Development Control
Ribble Valley Borough Council

Your ref: 23.0285
Our ref: D3.23.0285
Date: 27th June 2023

Address: Barn to the south of Grove House Malt Kiln Brow Chipping

Proposal: Proposed conversion of existing barn to a dwelling house. Together with rear extensions following demolition of flat roof

# SITE LAYOUT PLAN AS PROPOSED

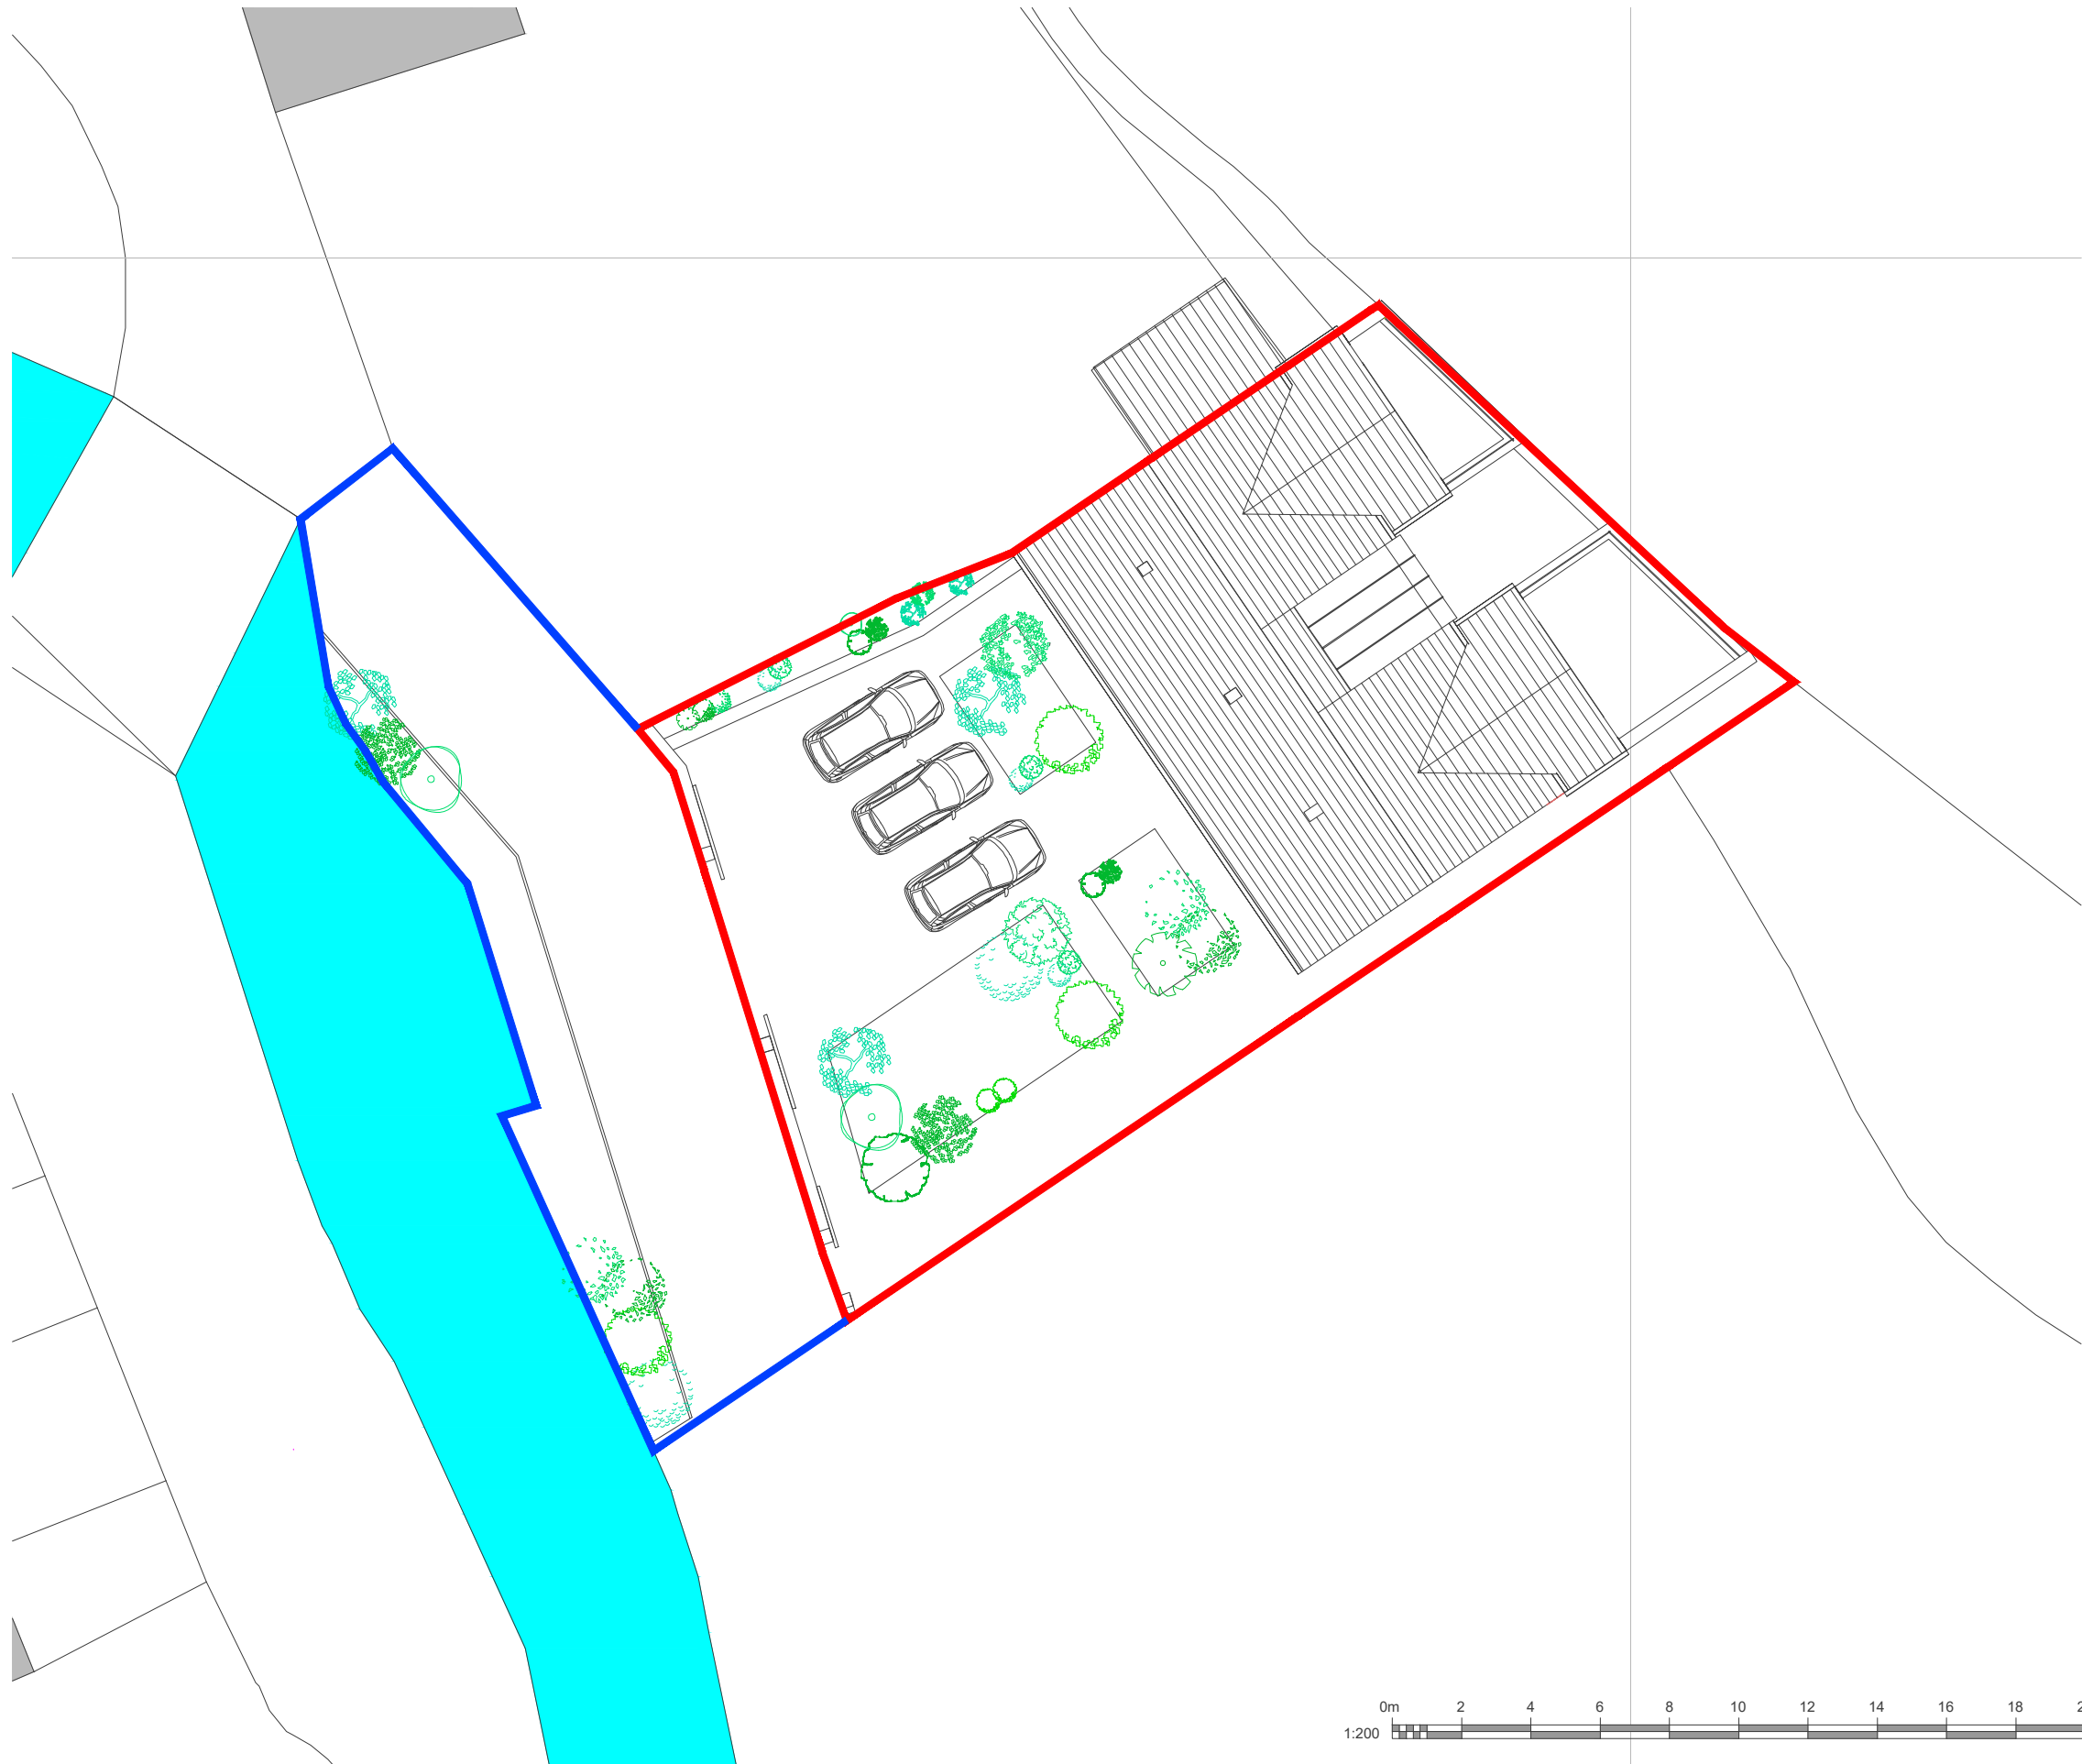
The access to the site is via an existing access on Malt Kiln Brow which lies at an acute angle to the highway and is located immediately adjacent to the river bridge. The access appears to have been used previously by the factory which has since been demolished.

The existing access width is approximately 3m wide and due to the tight angle it appears unsuitable for large construction traffic and further information is requested on any alternative means of access to the site to avoid any damage to the bridge parapet wall and or vehicles making multiple manoeuvres in the highway causing conflict with vulnerable highway users.

If this is the sole access to the site, then a swept path analysis is requested for a large construction vehicle to demonstrate it can enter and exit the site to and from the south on Malt Kiln Brow.

There are 3 car parking spaces proposed for the 4 bedroom dwelling which accords with the parking standards. A secure, covered cycle store is required at the dwelling to support sustainable travel modes.
